## **Observations on Consultation on Tre'r Gof offset additional land acquisition, Wylfa Newydd Project (Horizon Nuclear Power Wylfa Limited, January 2018)**

### **1. Perpetuation of potential material flaw in the Public Notice published 15.01.2018**

Figure 5-1 Locations considered for the radioactive waste management facilities (January 2016)

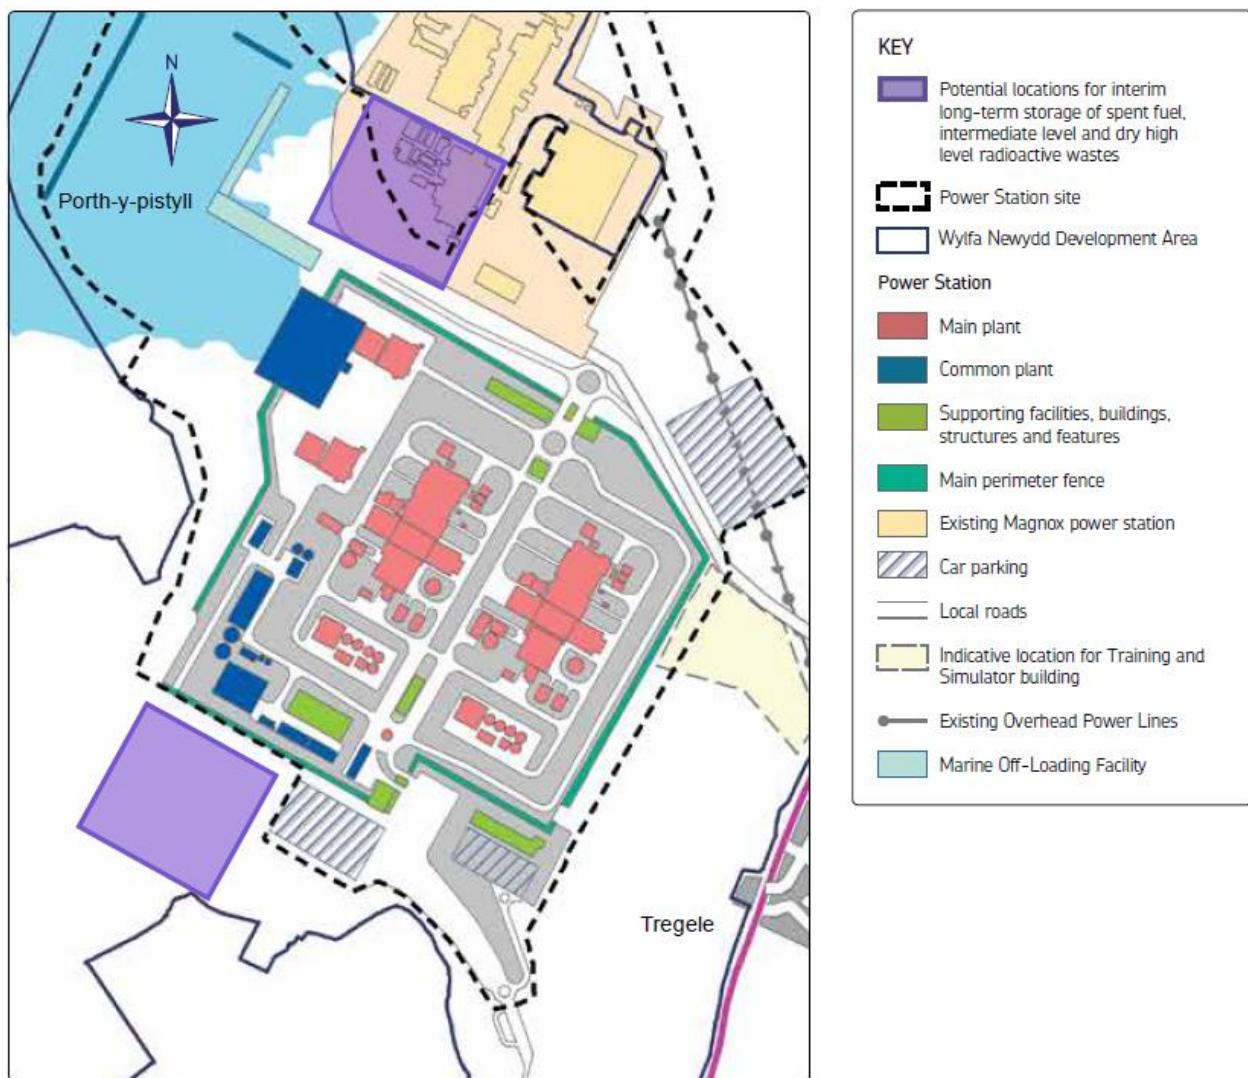
- 1.2.3 The remaining balance of two separate installations is shown grouped together as structure 4 in Figure 2.2. Structure 4 consists of an Intermediate Level Waste Storage Facility (ILWSF) and a Spent Fuel Storage Facility (SFSF). Both Facilities are situated next to one another, at the far south west corner of the Wylfa Newydd Development Area. Notably, neither Facility would be dismantled and removed when the nuclear reactors are removed, following decommissioning of

the “Power Station”. Their sole purpose is to bridge a time gap (of indeterminable length, at present) between the production of their respective contents and the availability of a Geological Disposal Facility (GDF), somewhere, ready to receive their entire contents and inventories for permanent disposal. Thus, their designation as Interim Storage Facilities which, as with the GDF, need not necessarily, or in principle, be located on the same site as the “Power Station”.

1.2.4 Notably, neither the ILWSF nor the SFSF have direct intimate routine day to day connection with the operation of the nuclear reactors, and do not in principle necessarily have to be located on the site of the “Power Station” itself. As a principle, the latter is adumbrated expressly in Annex B of the 2011 National Policy Statement on Nuclear Power Generation (EN-6 Volume 2). In other words, these two buildings are in essence and in principle primary stand alone planning developments, wholly independent of the “Power Station” DCO. The Public Notice fails to reflect this. It ill serves the public interest for a Public Notice to continue obscuring from the public gaze any underlying potential planning complication. Apparent failure to distinguish fairly between appropriate planning categories gives rise to manifest confusion in the public mind and, as such, is capable of rendering the Public Notice flawed.
